City of Albuquerque

**Re: Mygrant Glass, Meridian Business Park, Lot 9 Engineer Certification
Engineer's Certification dated 8-21-03, (K10/D43)**

**Re: Mygrant Glass, Meridian Business Park, Lot 9 Grading & Drainage Plan
Engineer's Stamp dated 11-12-02, (K10/D43)**

GRADING PLAN

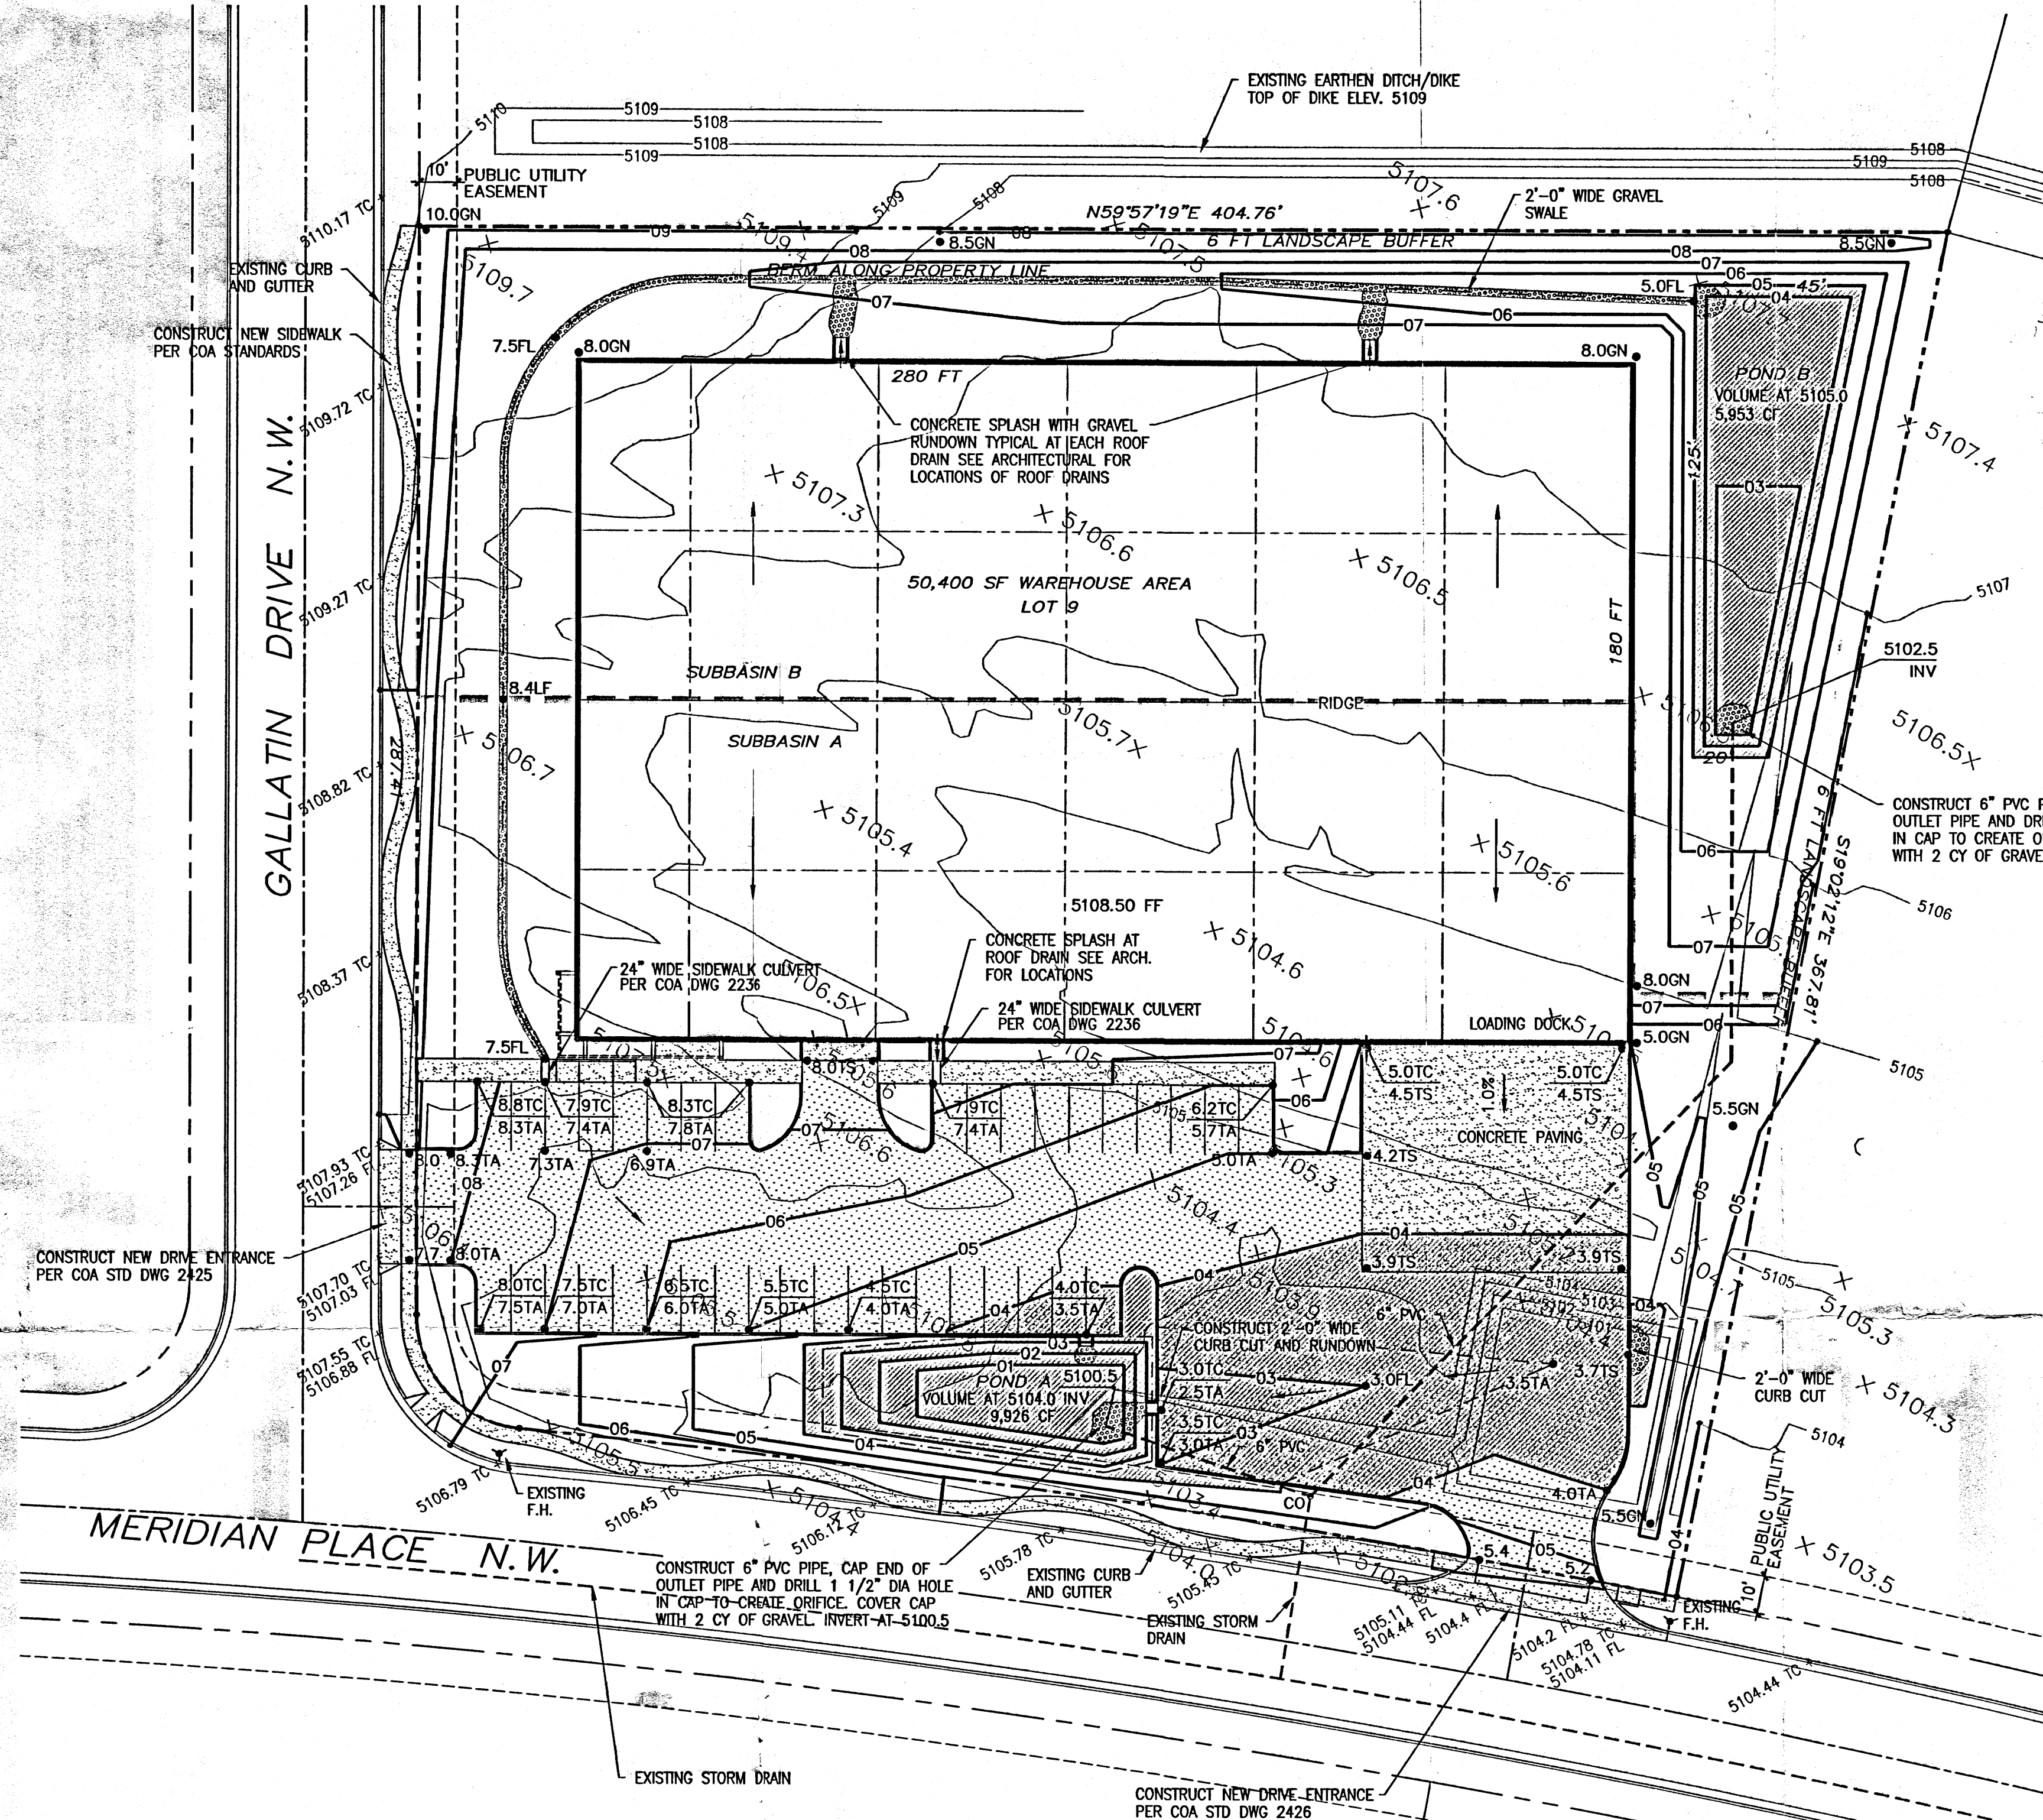
Based upon the information provided in your submittal dated 11-12-02, the above referenced plan is approved for Site Plan for Building Permit action by the DRB. Prior to Building Permit approval, please address the following comments.

- Please show the fire department travel route and provide a safe cross-slope for this route. I would like to make sure that this is really what the fire department wants.
- Show size and invert of the existing SD stub-out.
- Add orifice plate detail on this plan.
